Fall Mountain Farm Company Summary of Changes to the Application Package

PCD File No. AL2611

October 7, 2026

Special Use Request to Allow Agritainment Parking Greater Than 50 Vehicles

Site Plan 2026

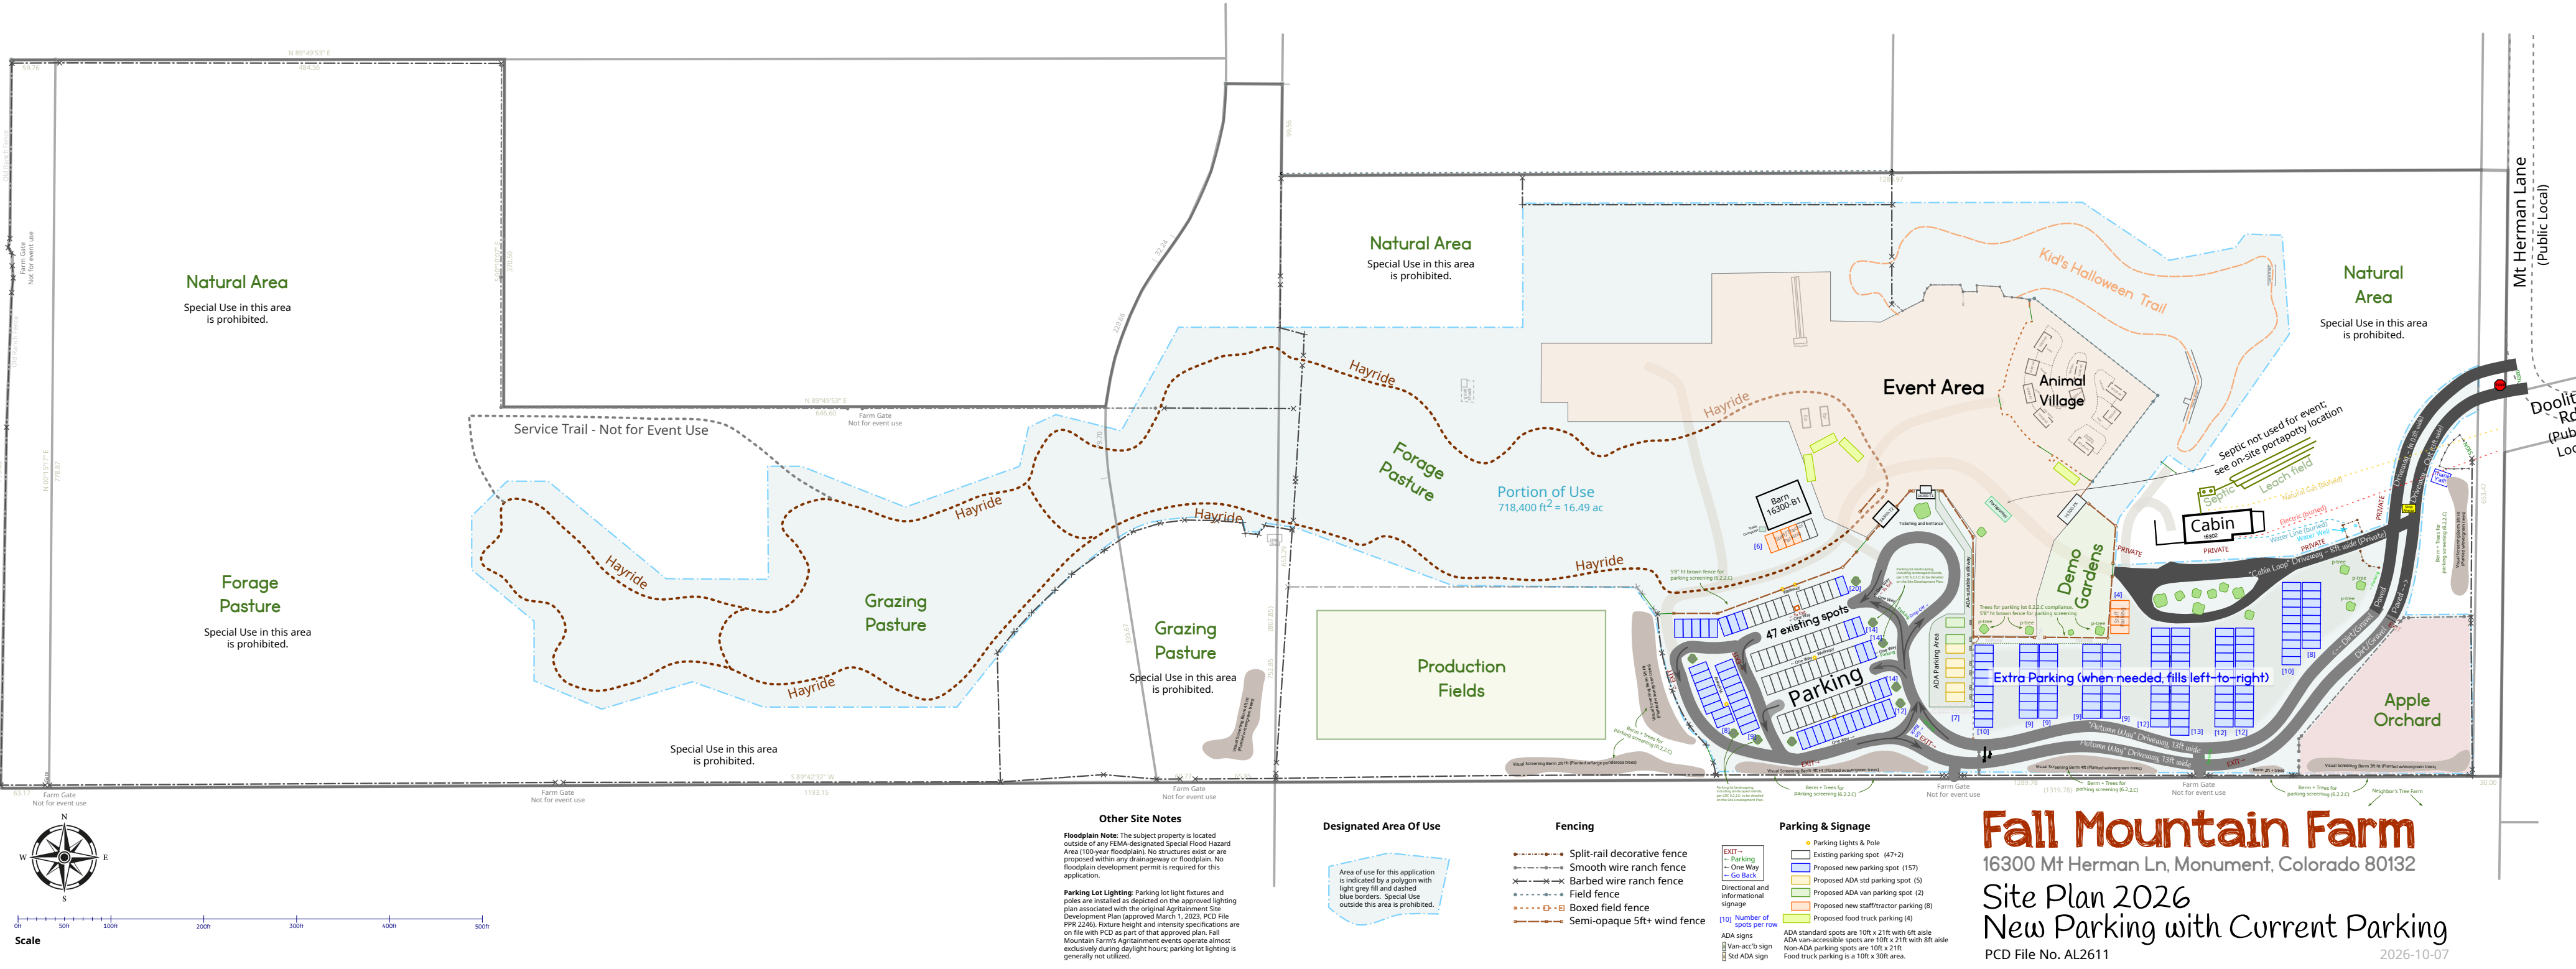
Item	Change
ADA Parking Area Detail	The County’s standard accessibility (ADA) note is added verbatim.
Parking lot landscaping	Note added at both parking areas: <i>“Parking lot landscaping, including landscaped islands, per LDC 6.2.2.C; to be detailed on the Site Development Plan.”</i>
Area of Use	Refined from 835,481 sq ft (19.18 ac) to 718,400 sq ft (16.49 ac). The Production Fields, and the retention pond area and berm north of the Apple Orchard, now lie outside the Area of Use. The boundary is also adjusted in several other places to follow the areas in use more closely. All event parking, the drives and entrance, the hayride route, the event areas, and the Apple Orchard remain inside. The note “Special Use outside this area is prohibited” is unchanged.
Title block	Dated 2026-10-07.
Labels	Minor label correction (“Service Trail - Not for Event Use”).

The parking layout and counts (225 vehicles) are unchanged.
